Application no: 21/02177/DISC

Location: : Proposed Roundabout Access To Graven Hill And Wretchwick Green,
London Road, Bicester

Transport Development Control

Objection to discharge of condition

**CONSTRUCTION TRAFFIC TO
ACCESS THE SITE FROM
THE A41 AND NOT THROUGH
THE GRAVEN HILL SITE**

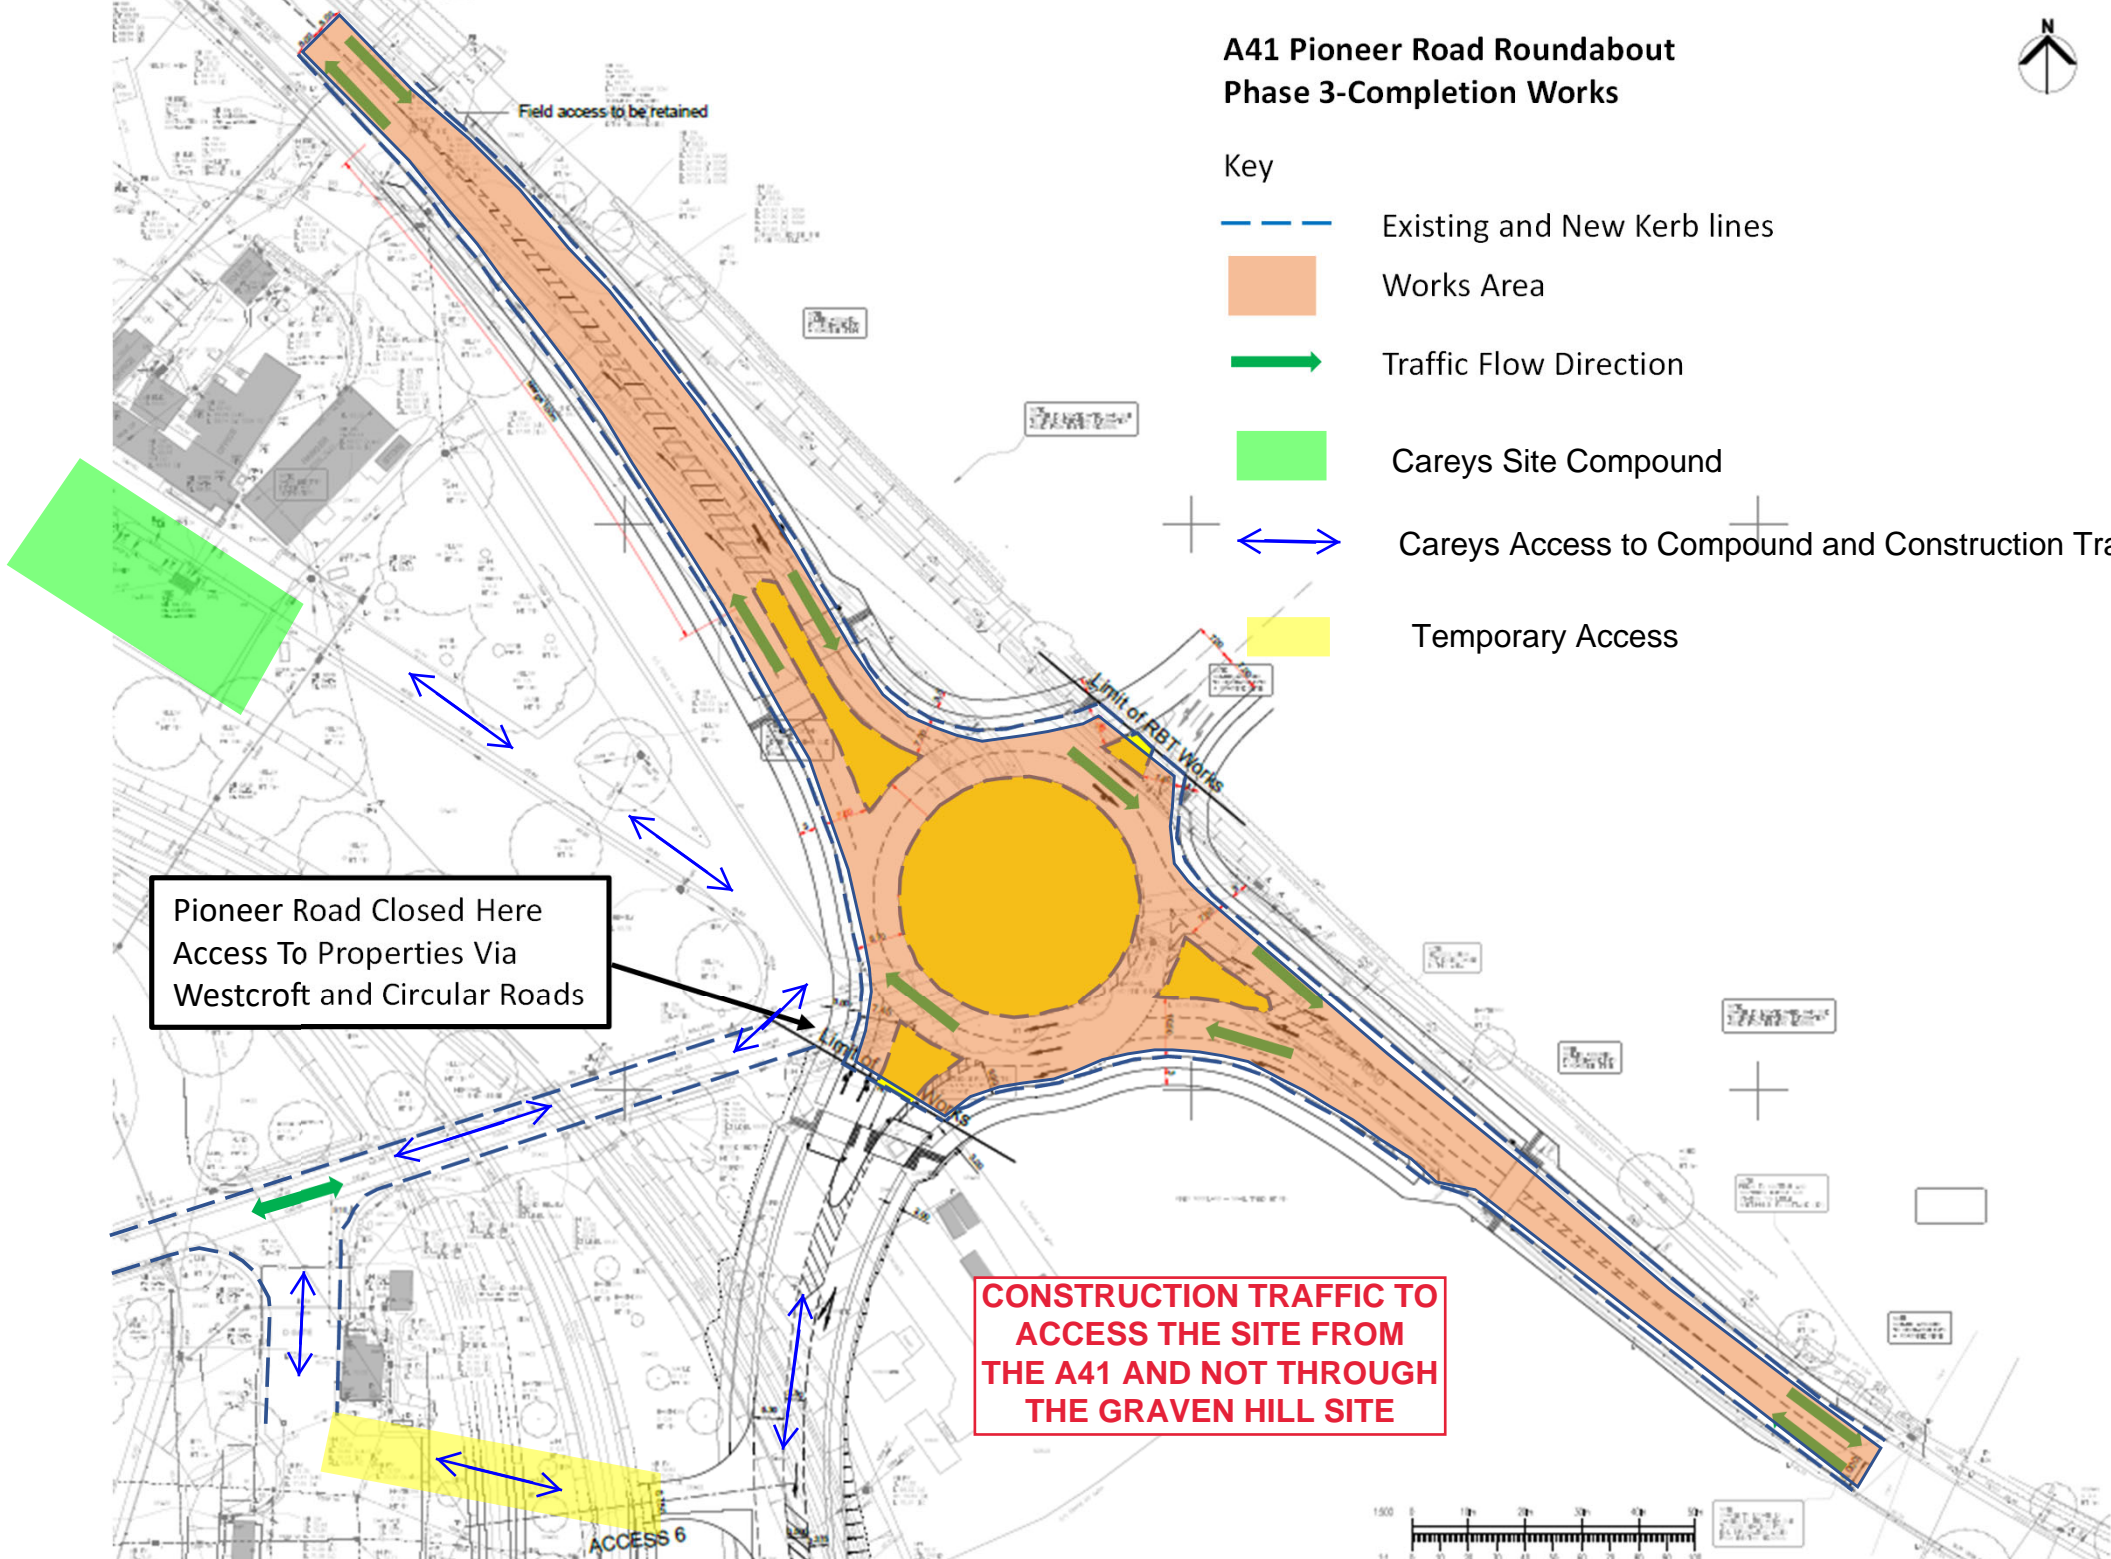
- No information is given on the access route to the site for construction traffic. I would expect this to avoid existing residential roads, including within Graven Hill.
- Insufficient information is given regarding the diversion of pedestrian and cycle routes, however, this would be subject to the agreement with the Highway Authority in connection with licenses issued for the works.
